**CITY OF ALBUQUERQUE  
PLANNING DEPARTMENT  
November 10, 2015  
DRB Comments**

**Project #1007188**

**APPLICATION # 15-70397**

**RE: Tracts 29-B & 30-A, MRGCD Map #34**

SKETCH PLAT OF
TRACTS A & B
LANDS OF ANNETTE & JOHN N. GALLEGOS
SECTION 6, T. 10 N., R. 3 E., N.M.P.M.
CITY OF ALBUQUERQUE
BERNALILLO COUNTY, NEW MEXICO
FEBRUARY 2008
SHEET 2 OF 2

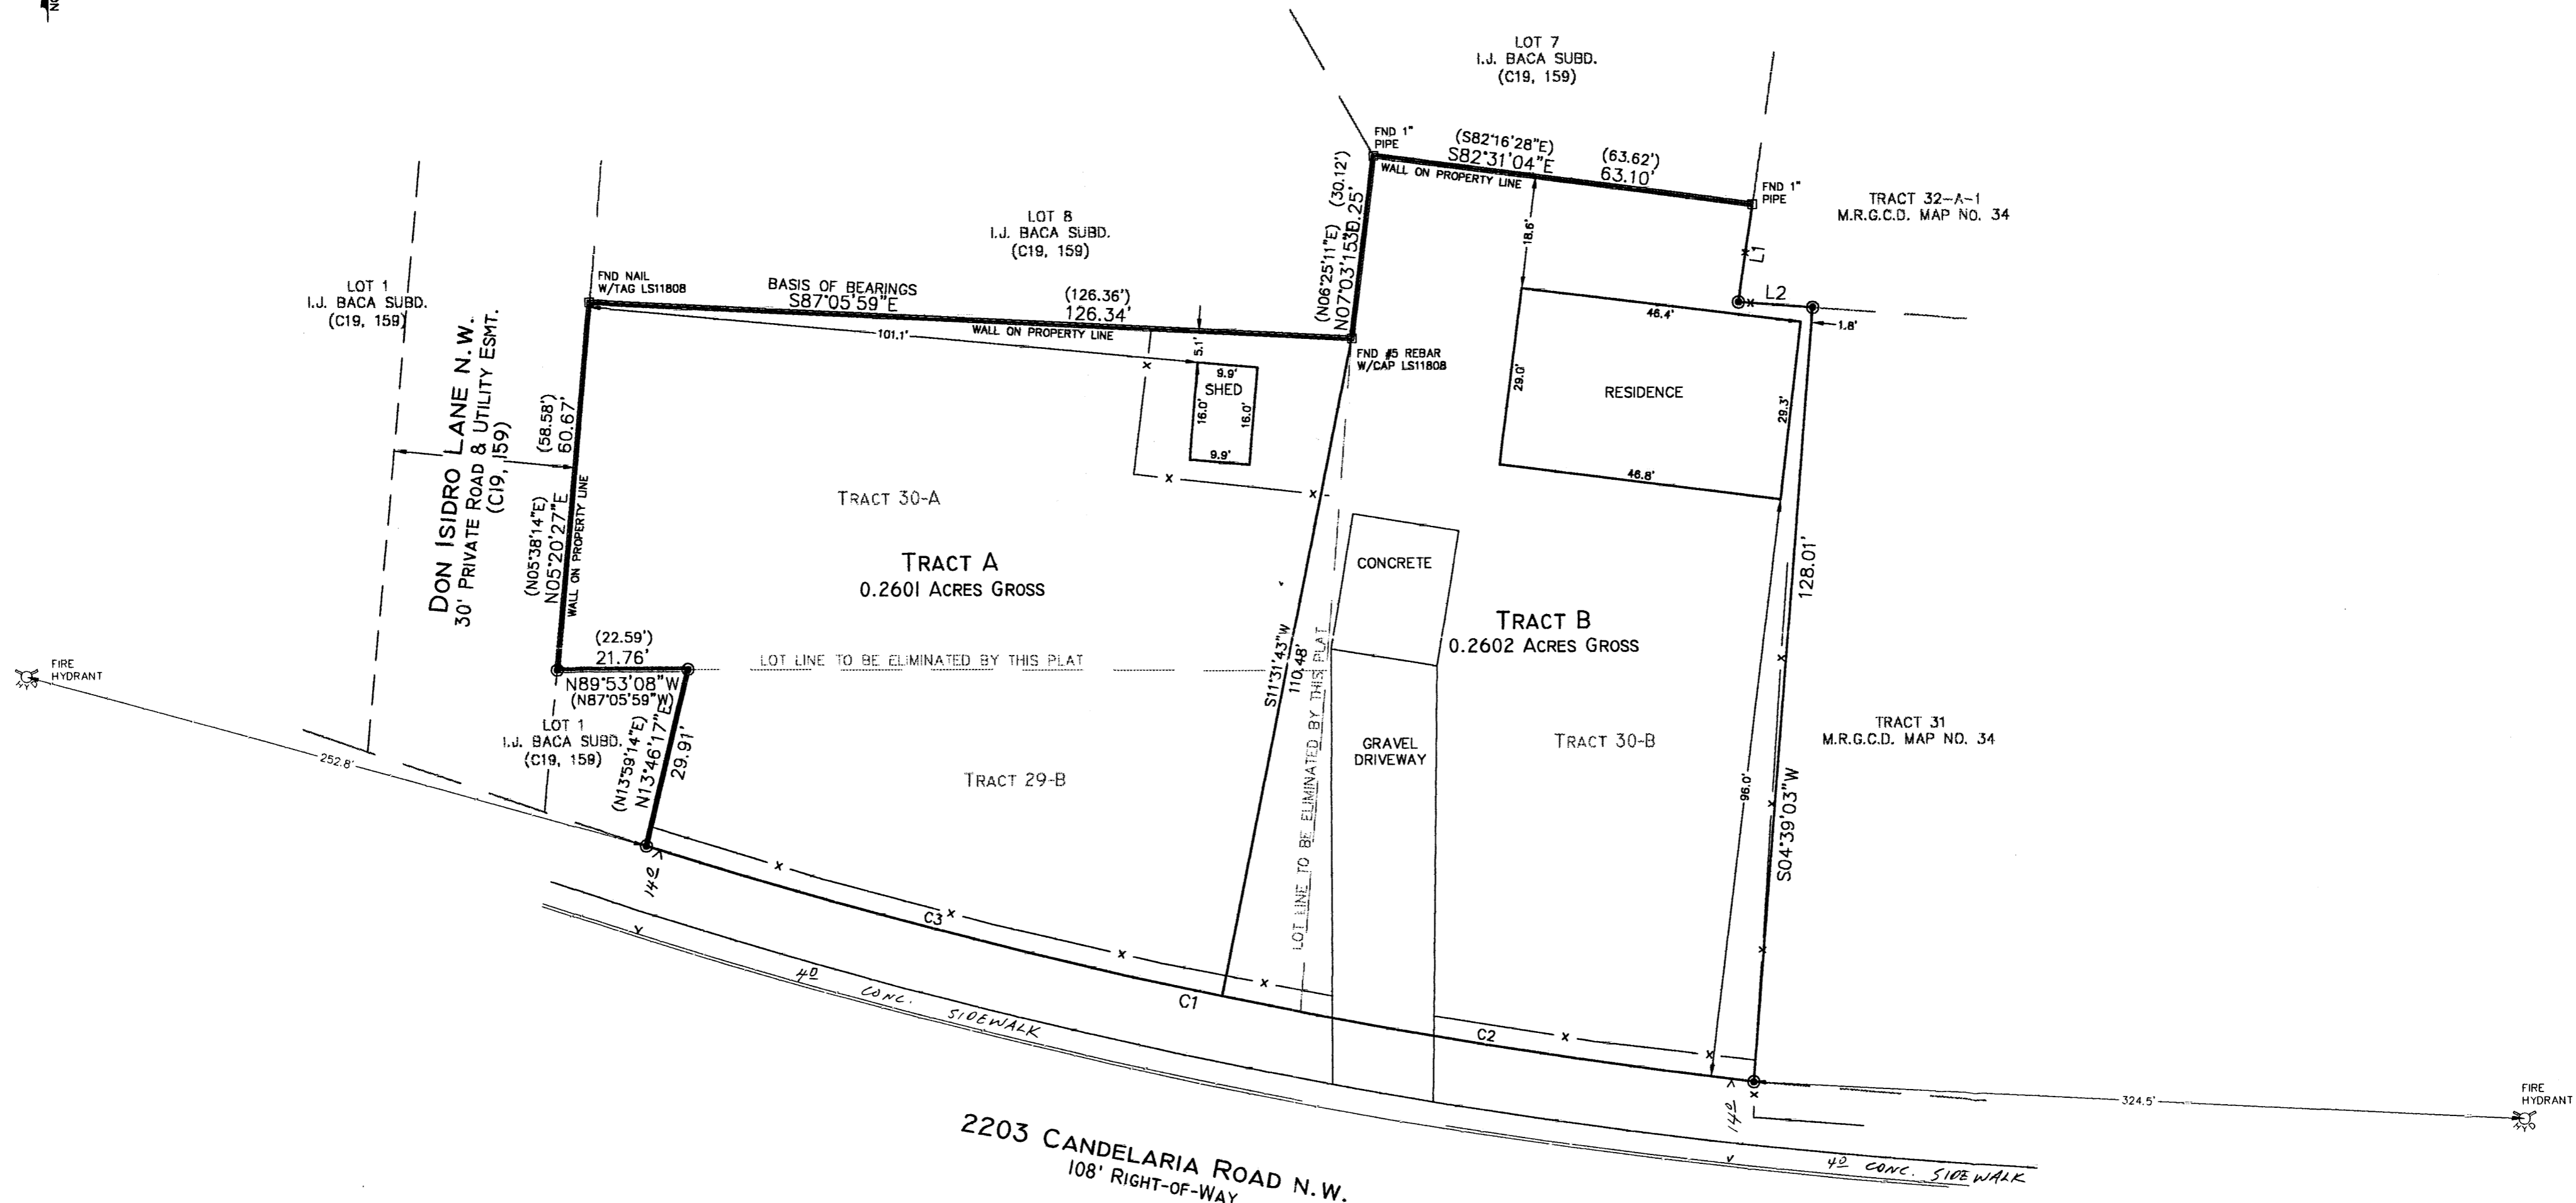
There is an apparent encroachment of a shed on proposed lot that would have to be removed.
